Transport  
for NSW

**New Request for Advice - Roseville College - New Sport and Wellbeing Centre  
(SSD-9912) (Ku-ring-gai)**

The EIS and supporting documentation provided in support of the SSD has been reviewed, and TfNSW comments are provided in **ATTACHMENT A**.

Figure 3.1: Sydney Trains network map (Source: TfNSW, 2018)

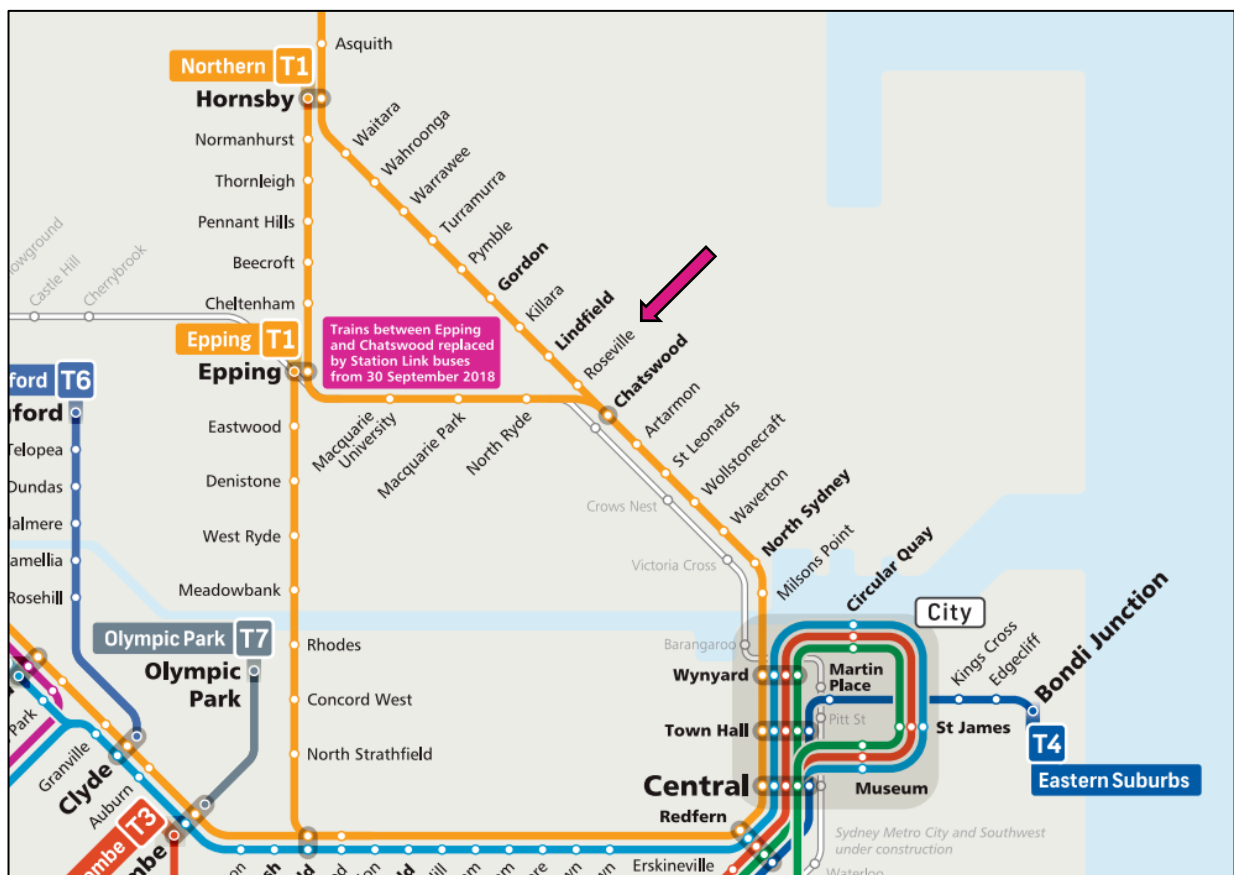
- Update Figure 3 with current version available online (should show completed Metro instead of StationLink).
